From: Hill, Grace <Grace.Hill@e-lindsey.gov.uk>
Sent: 02 June 2026 15:39
To: Niland, Mark
Cc: _planningadvice
Subject: H14-0083-26 ecology comments

H14-0083-26 - Kendall Grove Pinchbeck Spalding PE11 5AT

Reserved Matters application providing details of appearance, landscaping layout and scale. Erection of 218 dwellings including roads, public open space, drainage, infrastructure and landscaping - outline approved under Hybrid application H14-1218-21

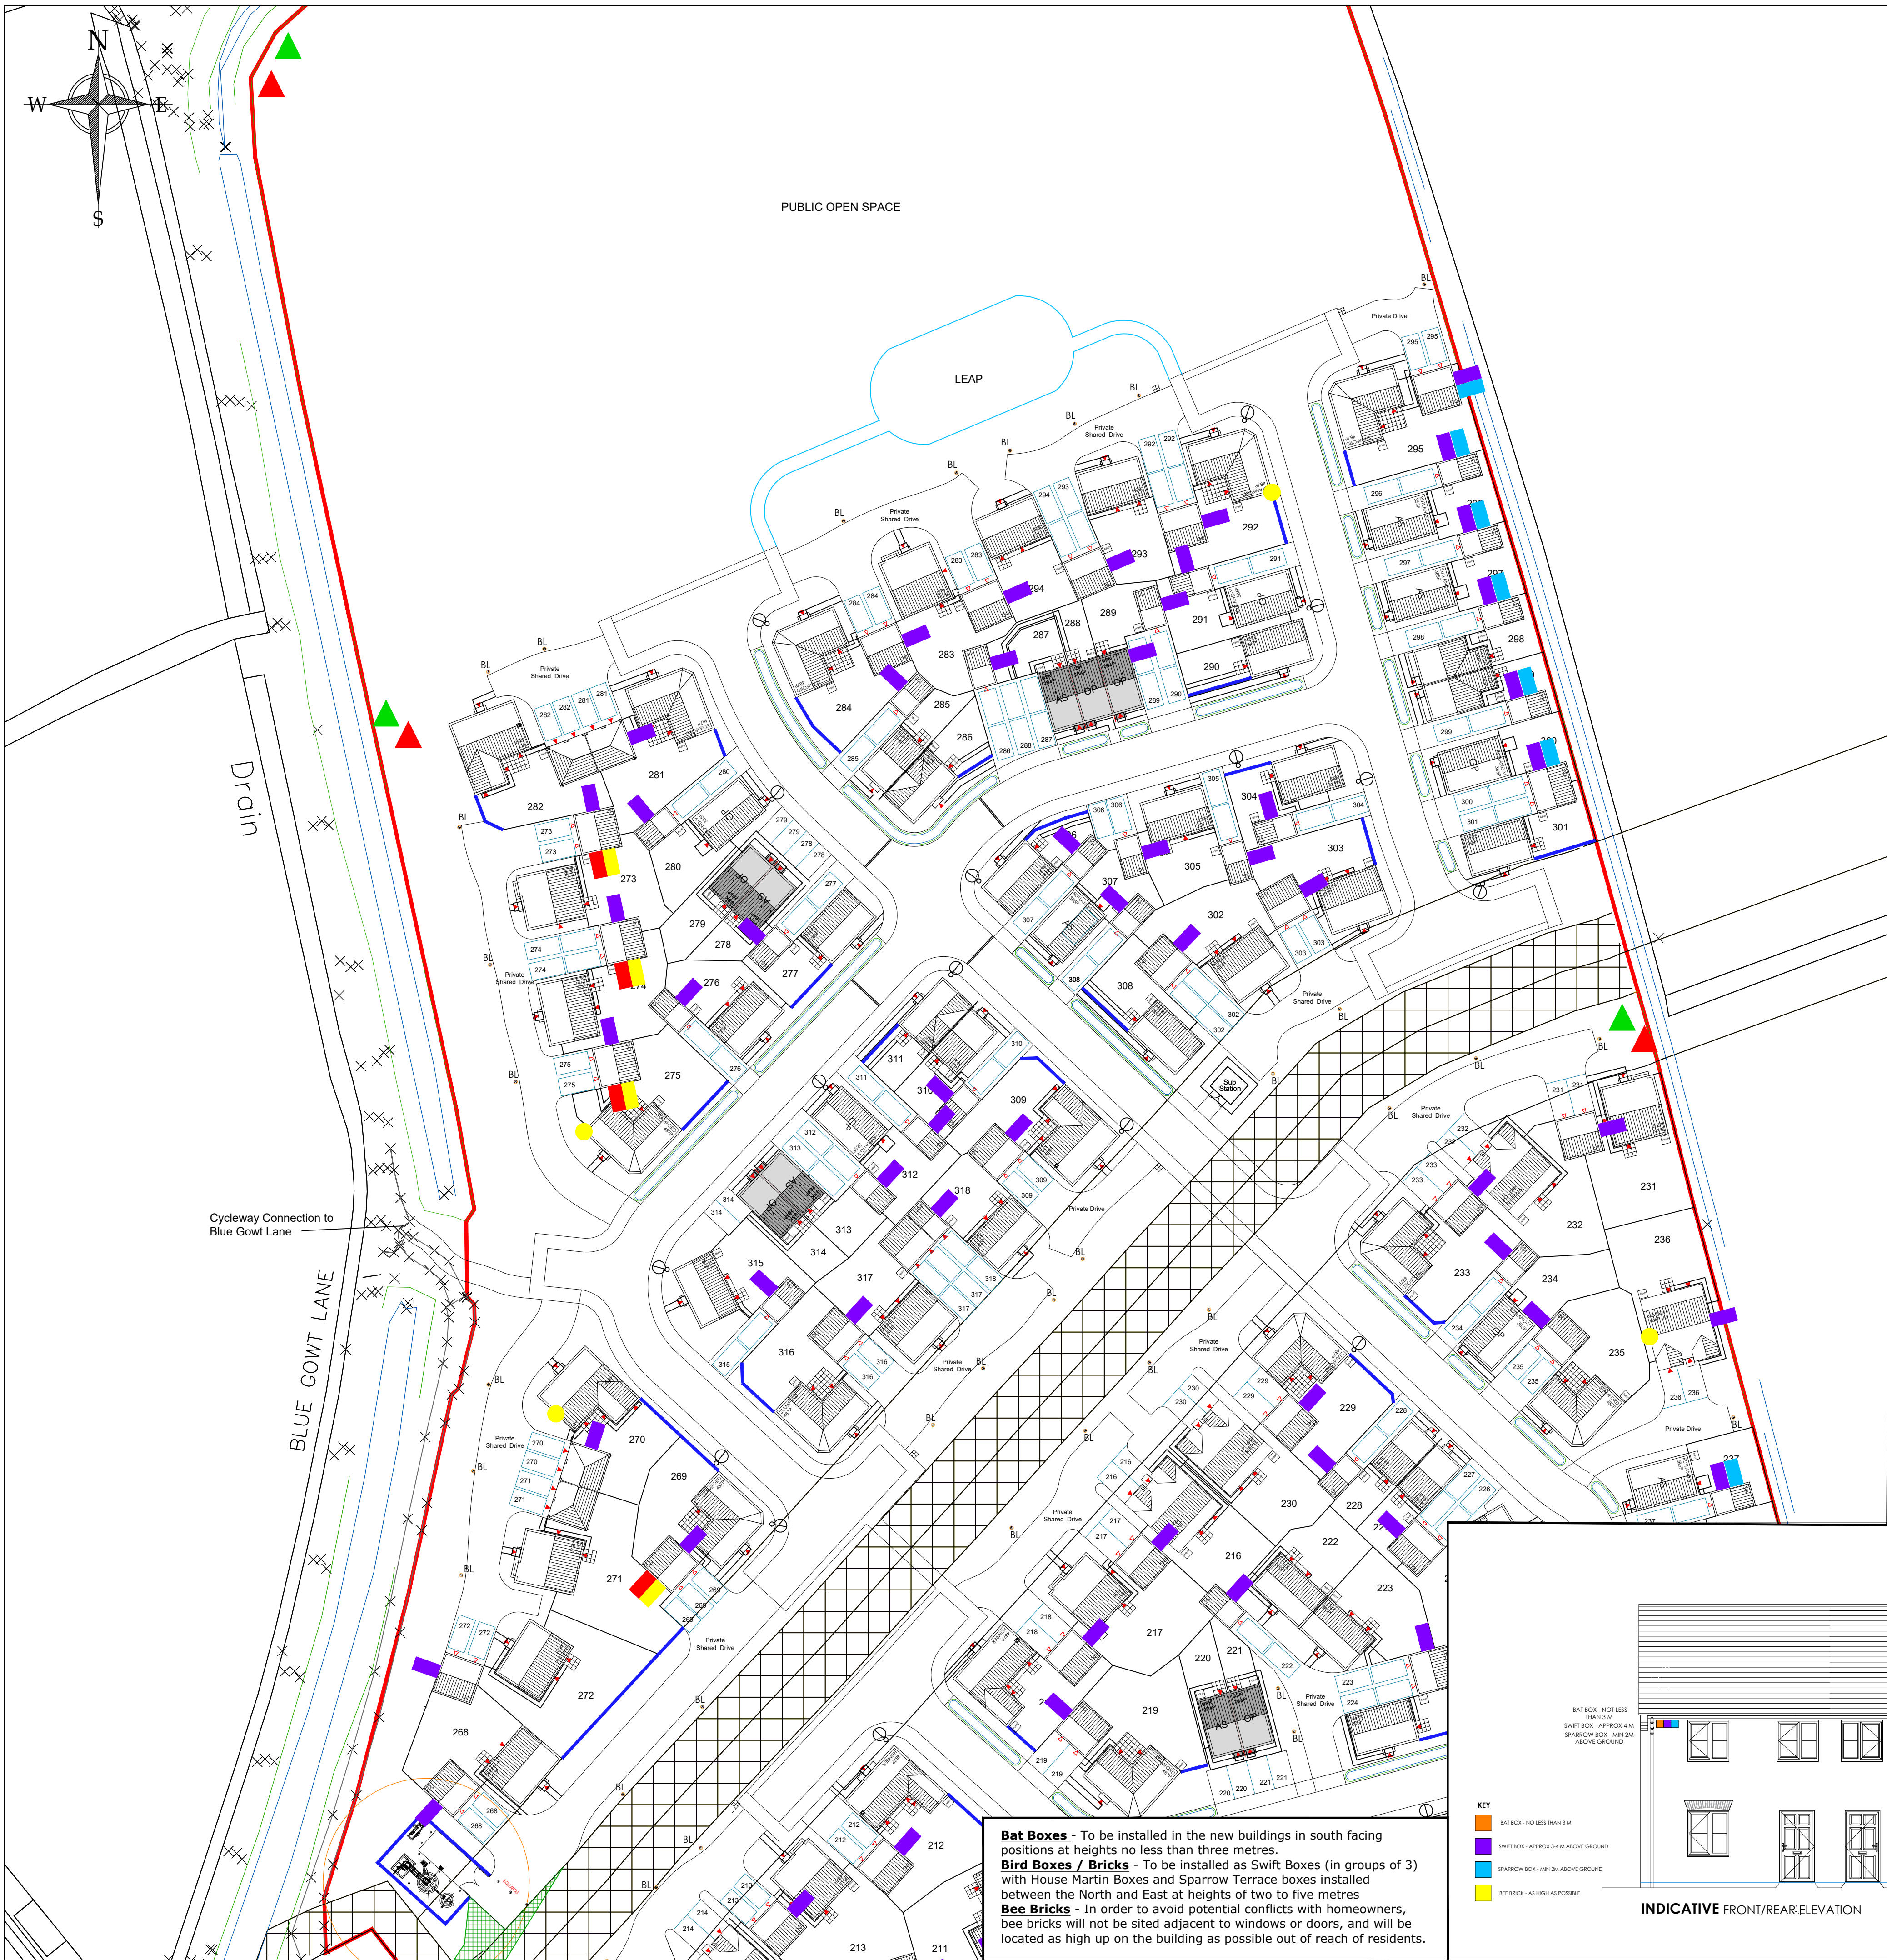
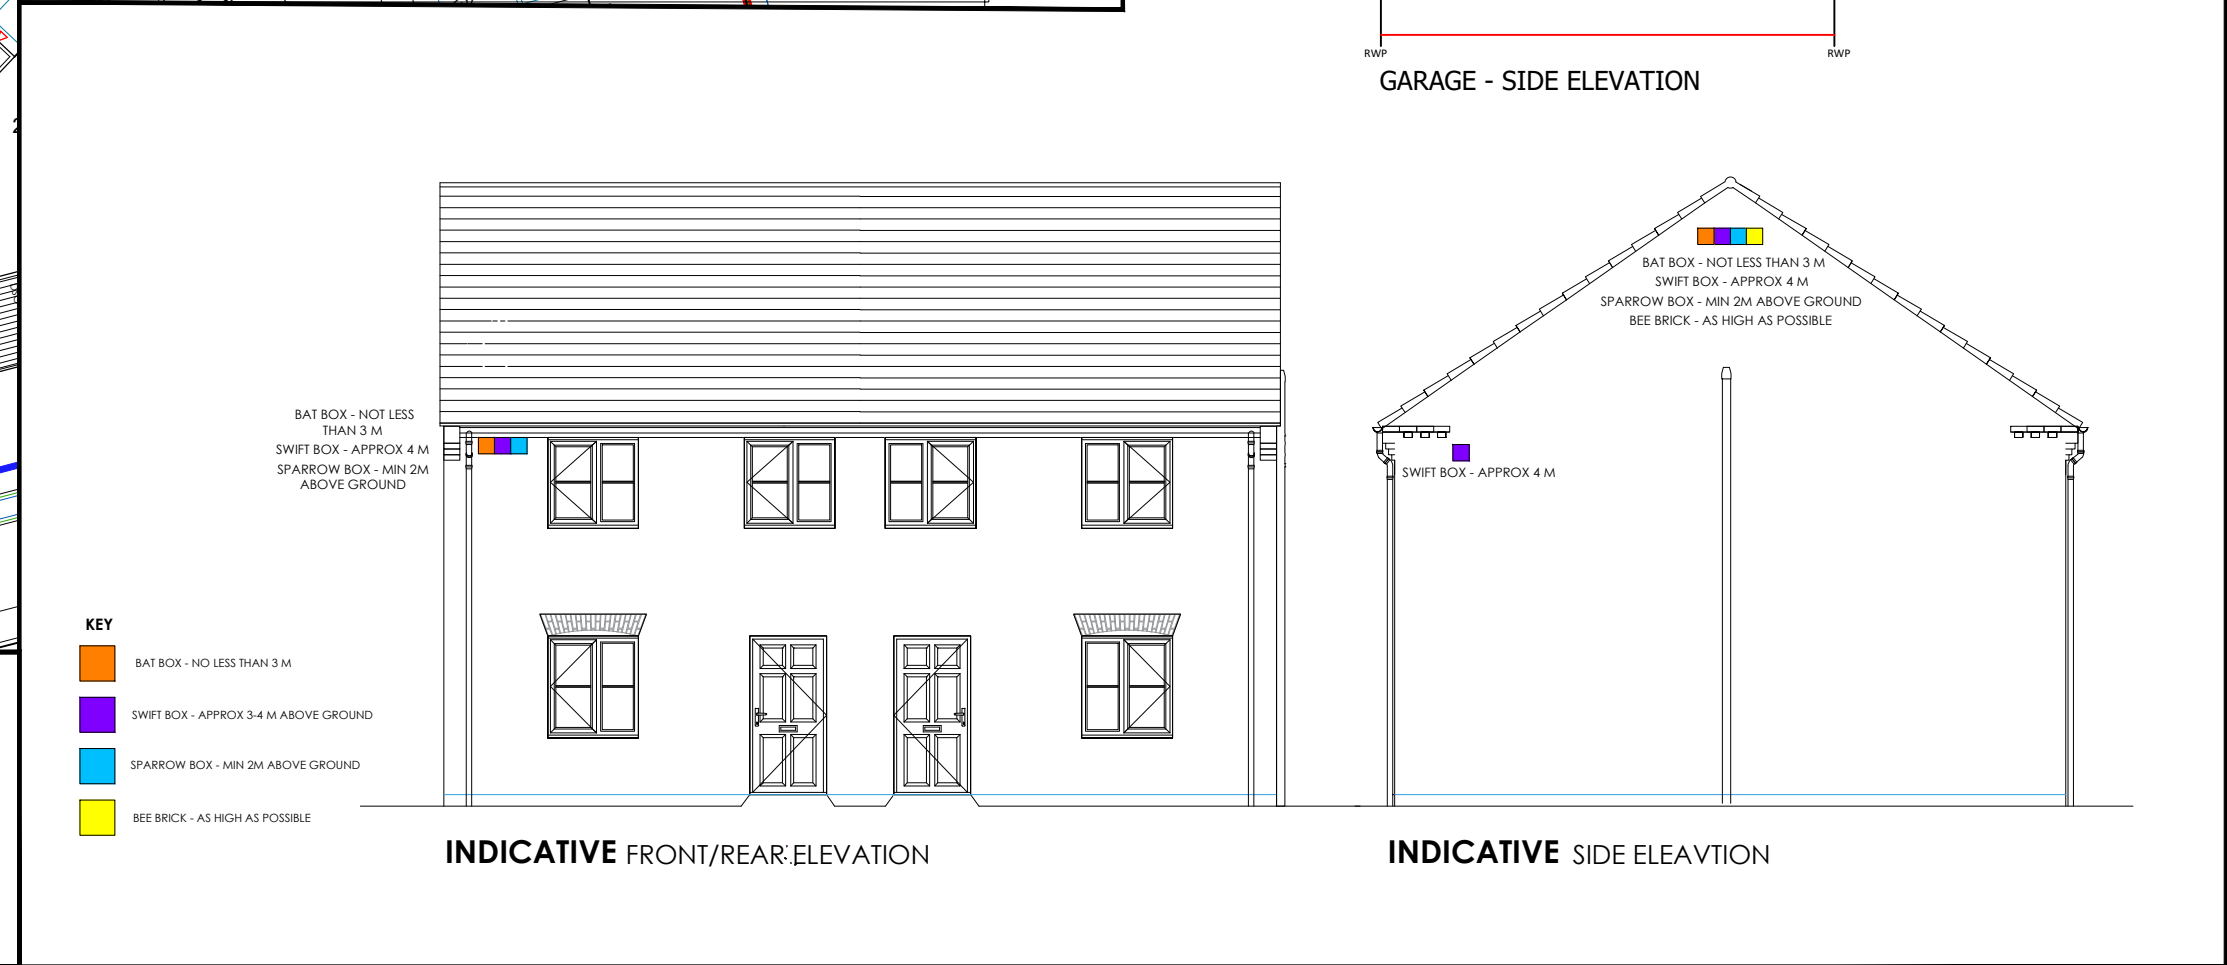
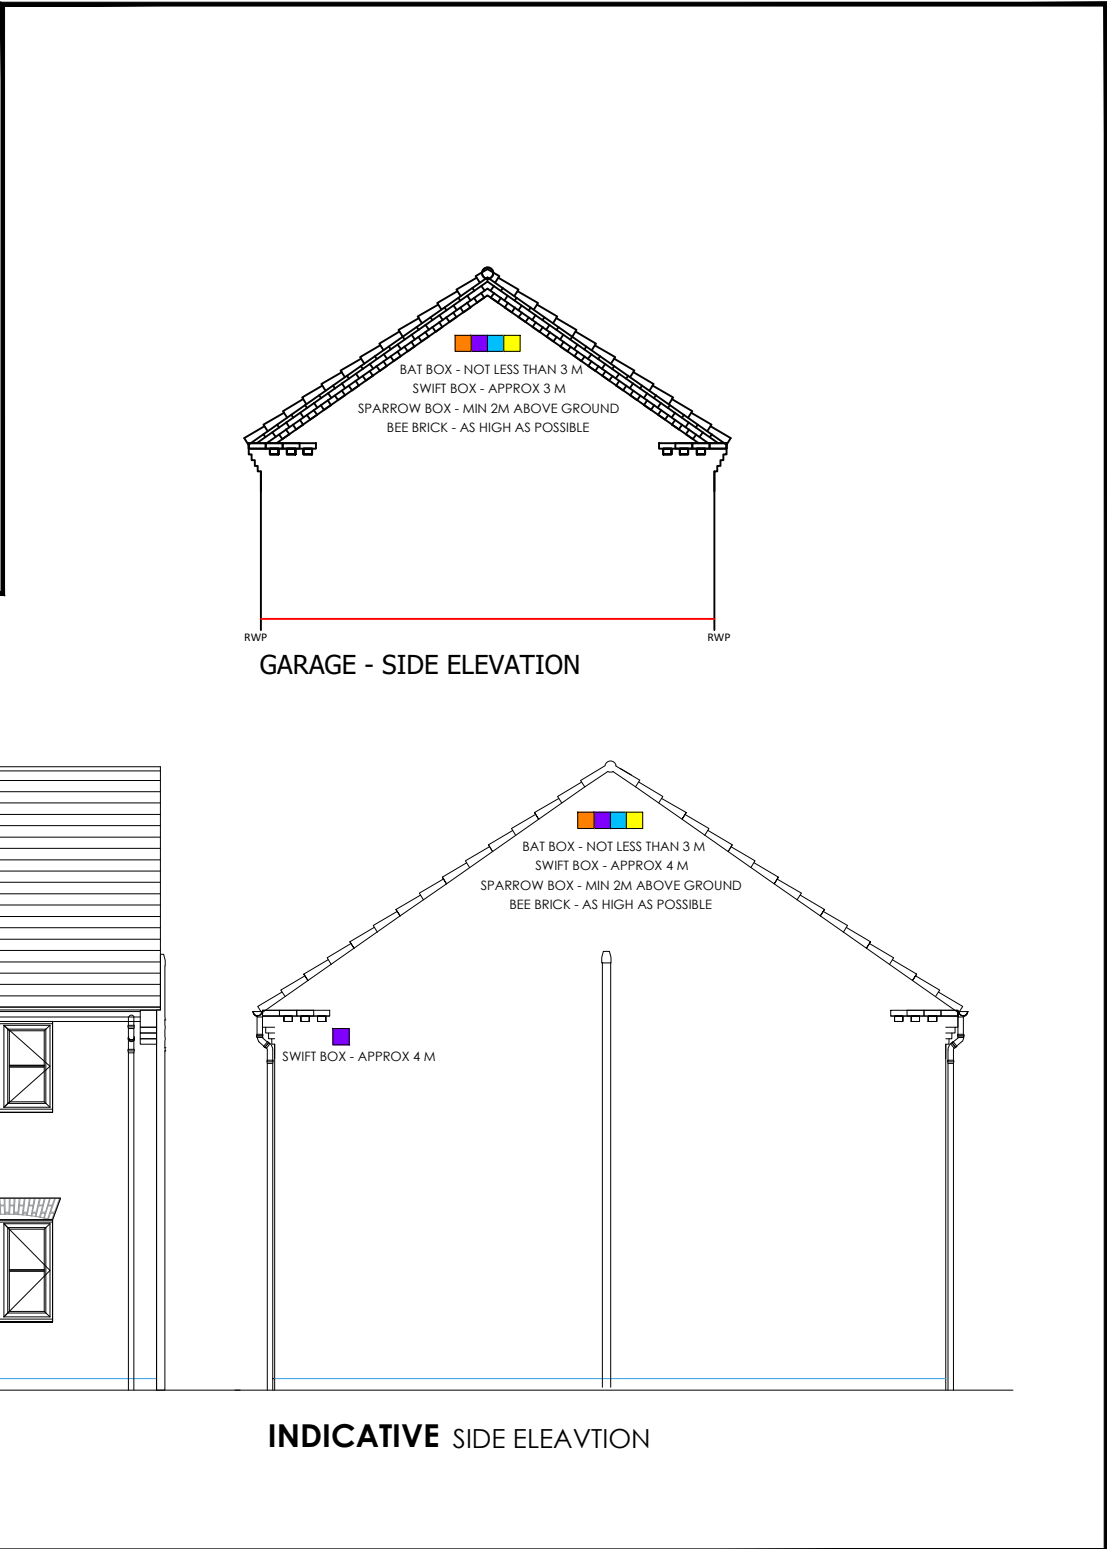
- We support the proposed biodiversity provision and ecological enhancements for this site, however, we strongly advocate that swift habitat be provided in the form of universal nest bricks that are integrated into the external material of the building as opposed to the wall mounted swift boxes that are currently mentioned in the Biodiversity plans for the site (e.g., S Brick, Swift Nesting Brick, Manthorpe, Swift Bricks: The 'Universal' Nest Brick – by Dick Newell | CIEEM. - <https://cieem.net/swift-bricks-the-universal-nest-brick-by-dick-newell/>). Reason: Integrated bricks have much better longevity and require no maintenance in comparison to externally mounted nest boxes, which weather, fall off, or can be removed.

- We also request that the locations for these swift bricks are altered to be placed on buildings at or above 4m from the ground. For example, they would be more suitably placed under the eaves of the main buildings rather than on the garages as proposed in the biodiversity plans. Swift bricks should also be grouped colonially (e.g., 3+ bricks on every third house in suitable locations) on the North/North-eastern aspect of buildings.

- Once these alterations have been made to the biodiversity enhancement plans for the site then we shall review the alterations and provide further comments.
